COUNTY COUNCIL'S RESPONSE TO CONSULTATION ON THE FOLLOWING DEVELOPMENT PROPOSAL

Application No: 18/01309/REM-2

Proposal: Reserved matters application for 14/02156/OUT - appearance, landscaping and layout (including the layout of the internal access roads, footpaths and cycleways) for 58 dwellings

Location: Land South Of Cotefield Business Park Phase 2 Adj To Blossom Field Road, Bodicote

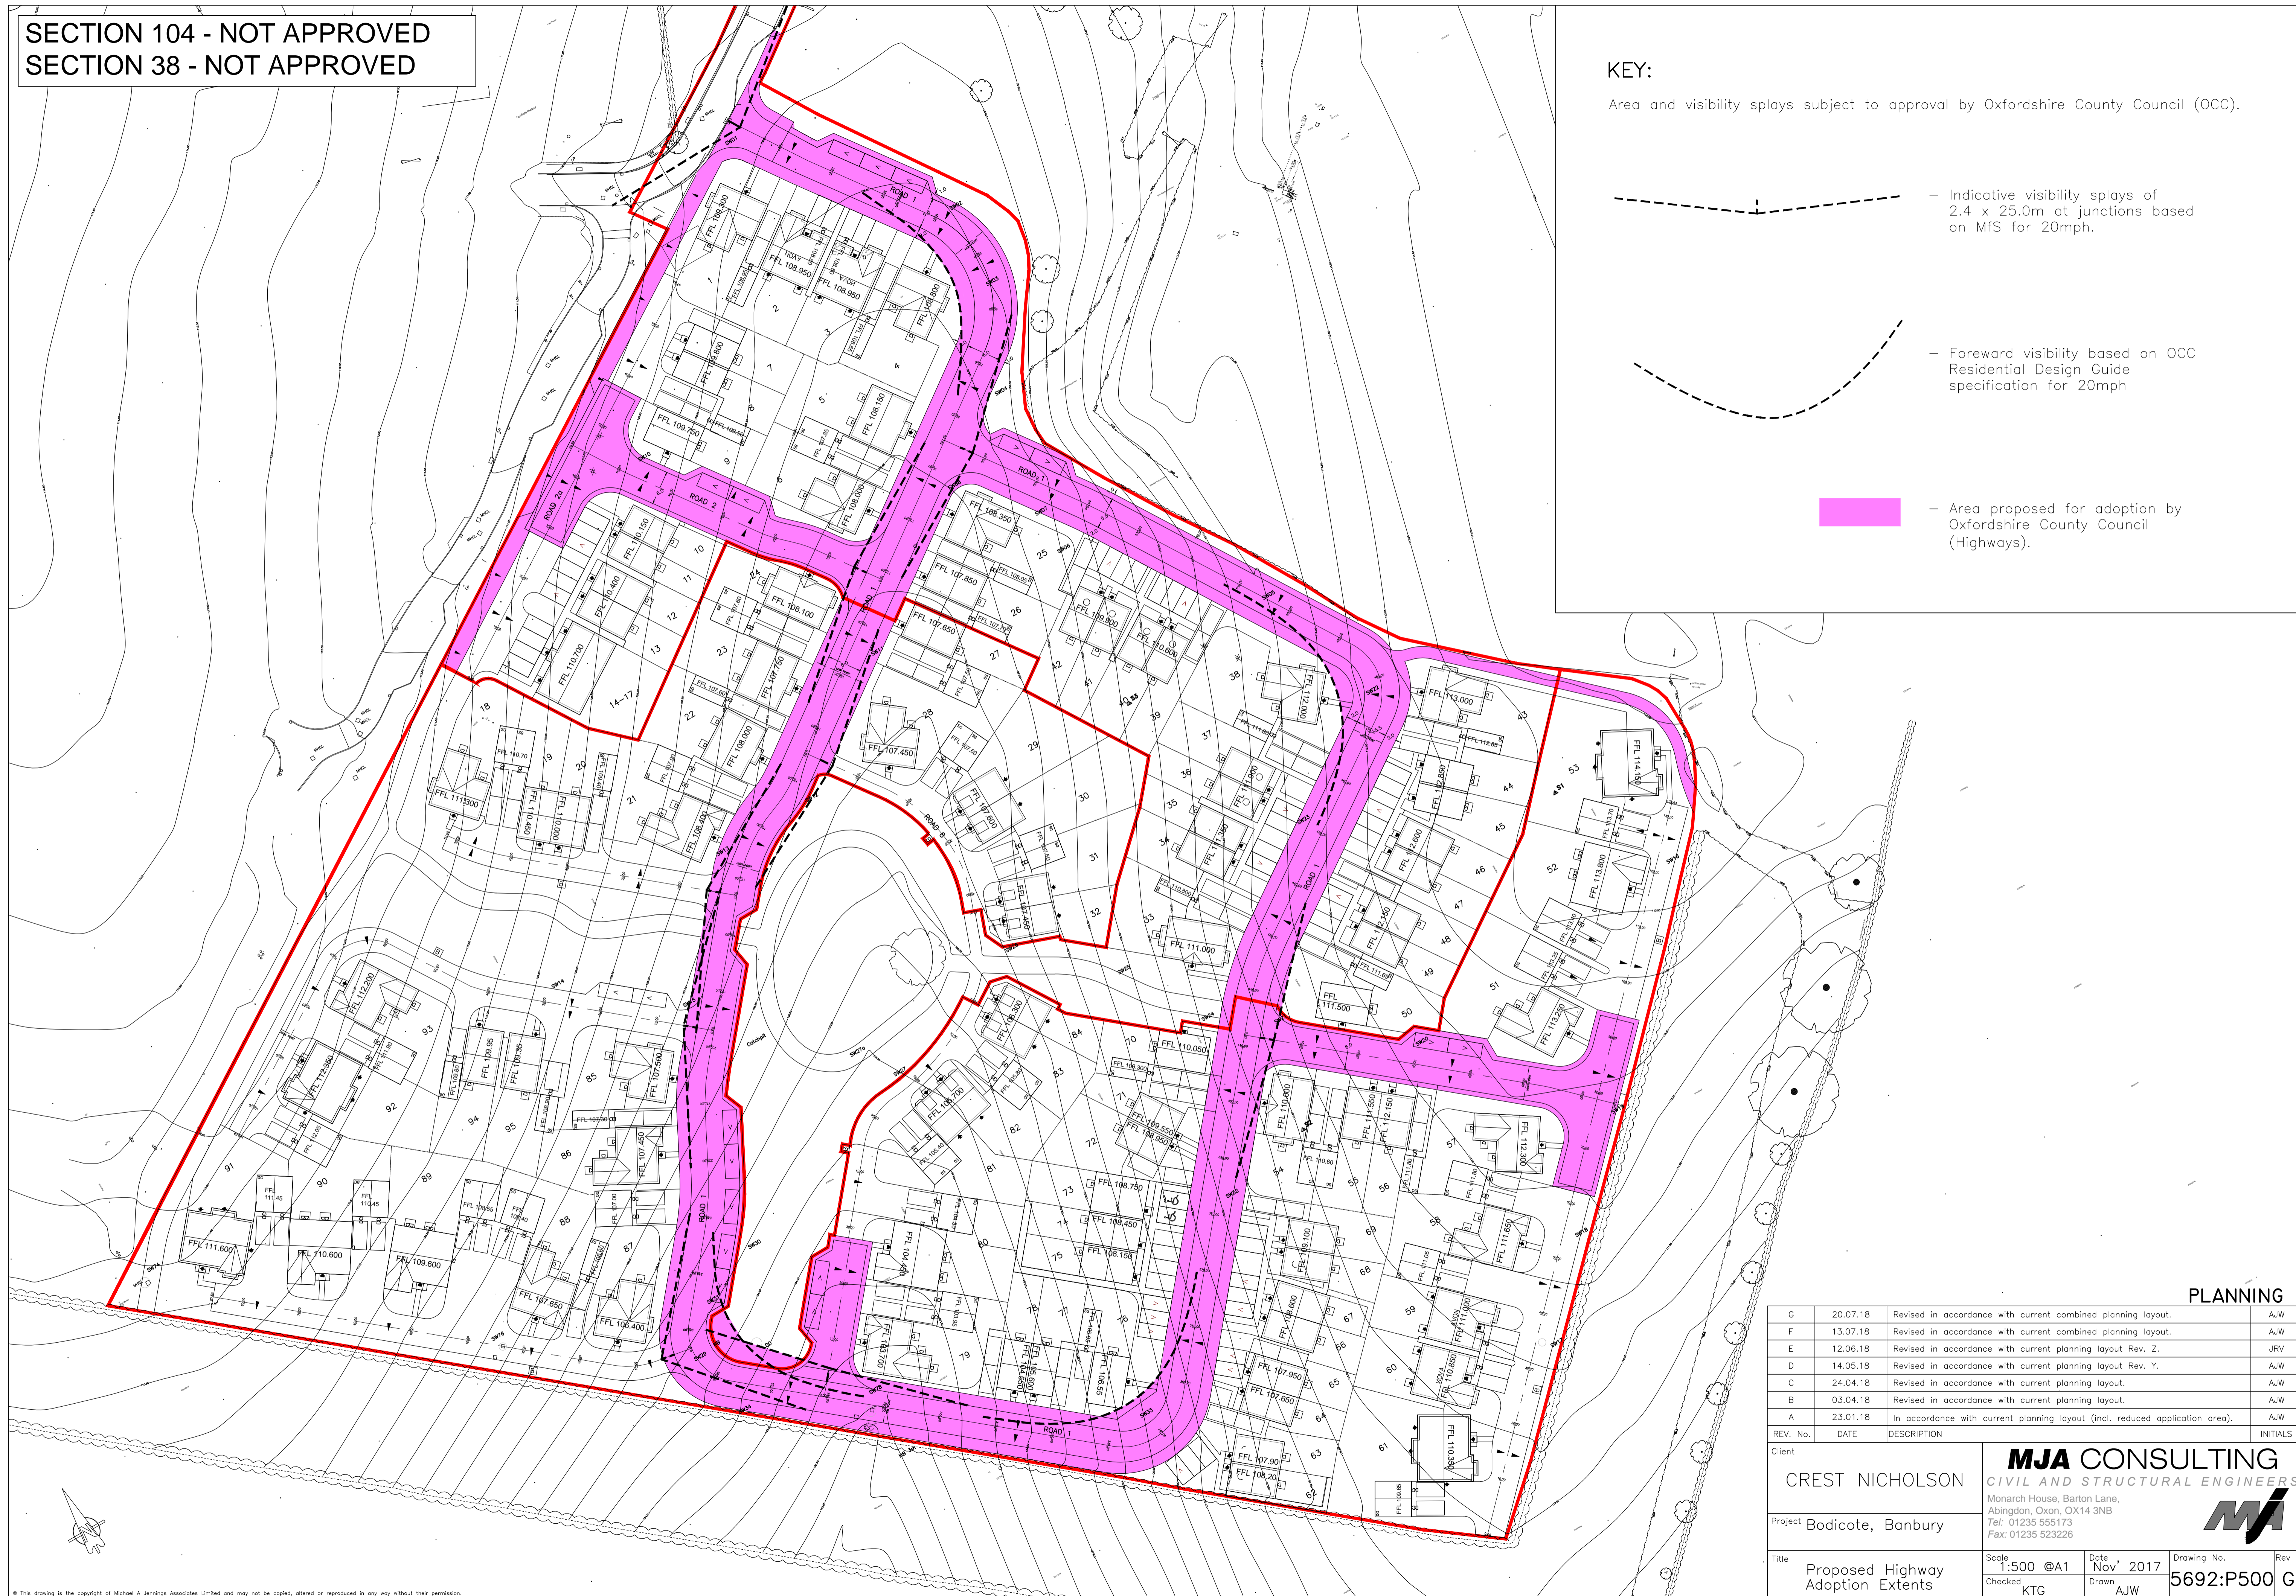
Drawing No. 5692:P500G. Forward visibility opposite plot No.87 around bend goes through a visitor parking bay. This is not acceptable and the parking bay should be removed from the splay. It is noted that gaps are shown between this provision of visitor parking bays. Capacity would be better used if bays are butted up to each other as per the standard practice. **This item is now resolved. No objection.**

Drawing No. 5692:P500G. The County would not adopt the area in front of Plot Nos.79 and 80. **This item is now resolved. No objection.**

Drawing No. 5692:P500G. The footway link to the side of plots 43 and 53 stops at the red line boundary and it is not clear whether it ties in with any existing provision. The County would not adopt this link if it does not link to highway. **This item is now resolved. No objection.**

Drawing No. 5692:P500G. Parking outside plot No.62 is not ideal on the bend. Cars reversing out will have difficulty in peak times. **The applicant states that “there is no alternative location for these parking spaces”. However, the applicant should explore removing the footway from the site boundary side, locally narrowing the carriageway to 4.8m and providing longitudinal parking bays along on the straight road. Reason for objection.**

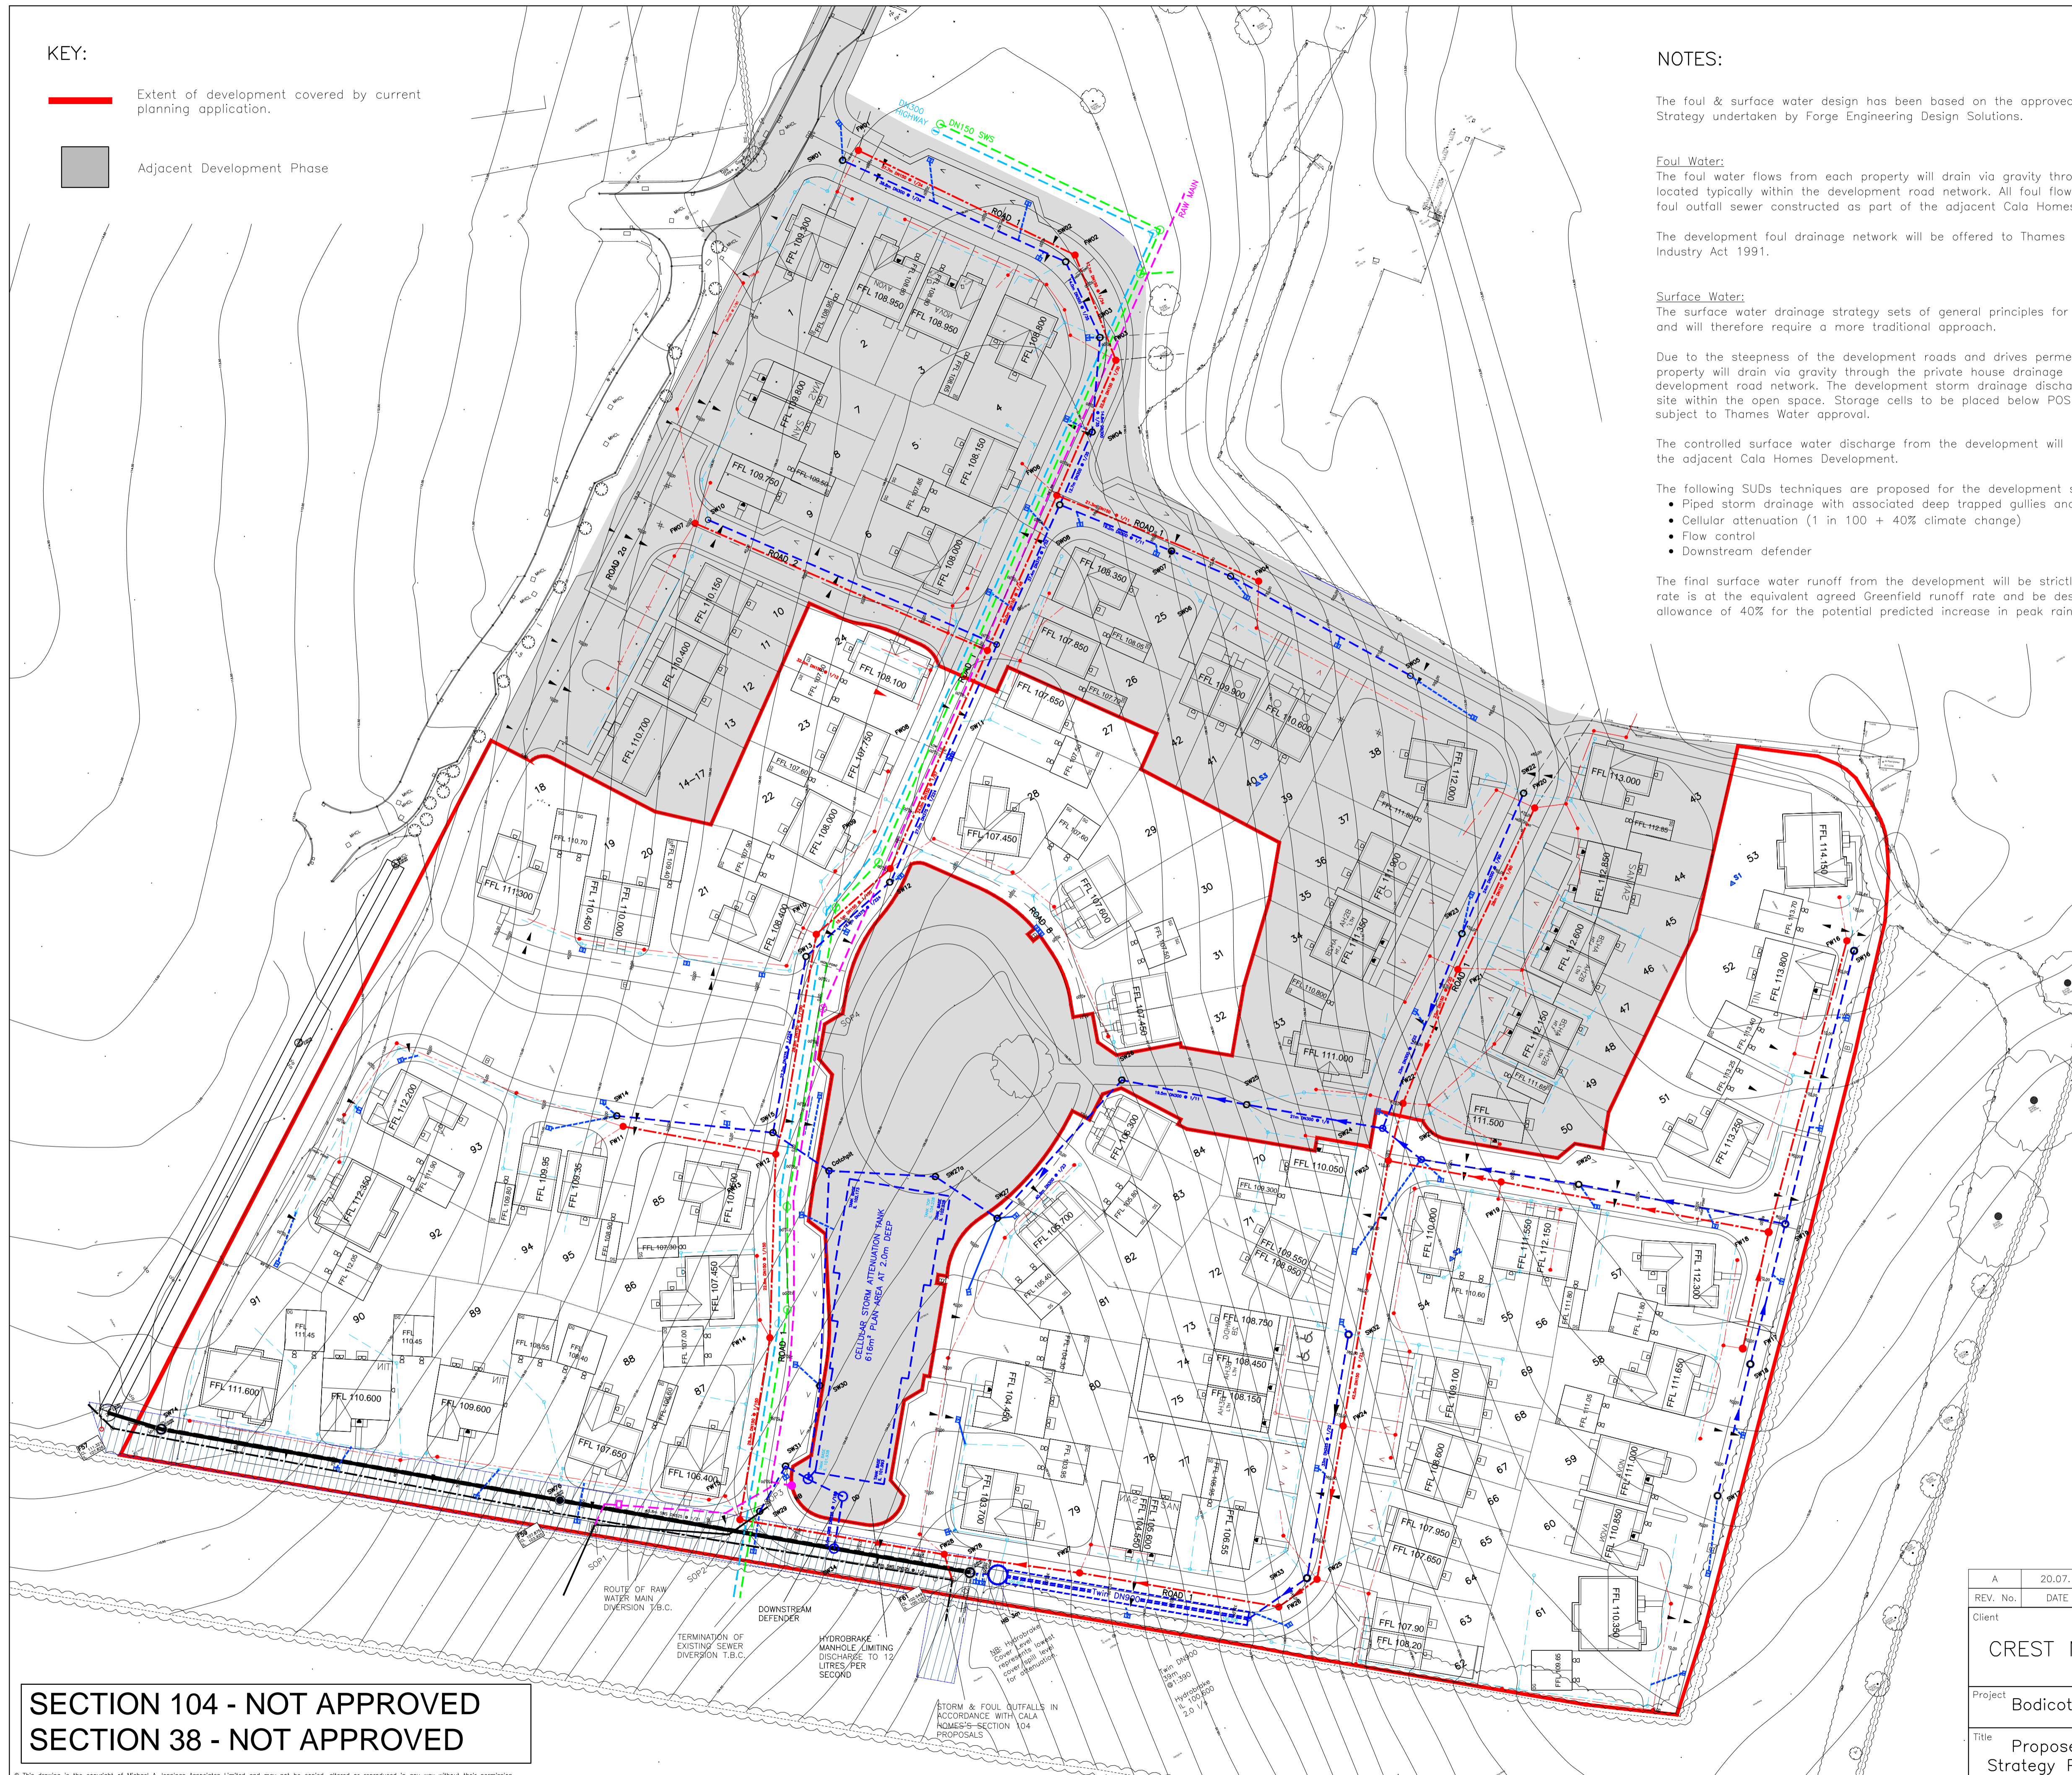
The outline application for this site (14/02156/OUT) included a Flood Risk Assessment by Forge Engineering. Testing demonstrated an average rate of $3.15 \times 10^{-6} \text{m/s}$ across the site. The original drainage proposals included permeable paving and soakaways to manage surface water. This was in accordance with the SuDS hierarchy of disposal of surface water, infiltration of surface water to ground being preferred to off-site disposal. The groundwater table was not encountered in 5 of the 6 trial pits, which were excavated to a maximum depth of 2.250m.

The drainage proposals accompanying this Reserved Matters application (18/01309/REM) highlights the risk of slip planes and springs to occur between limestone and clay layers at the site if infiltration were used due to site gradients. The current application proposes a conventional drainage system and underground attenuation tank to manage surface water.

However, the County considers infiltration may be possible in some areas of the site. It is understood that a neighbouring Cala Homes site does use infiltration techniques where practicable. The County considers some infiltration may be possible on lower

areas of the site, and expects that the Applicant seeks the advice of a geotechnical specialist to confirm the assertion that slip planes could develop if infiltration were used on higher areas of the site. Given the proposed absence of the use of any infiltration at the site, the County objects to the application. **The applicant argues that this issue can be dealt with in discharge of Condition 12 (Drainage) of the outline consent (14/02156/OUT). The County accepts Applicant's response that the drainage details do not form part of the planning approval for the REM stage, and that the required drainage details will be submitted as part of the approval of the surface water condition No.12 of the outline consent (14/02156/OUT). No objection.**
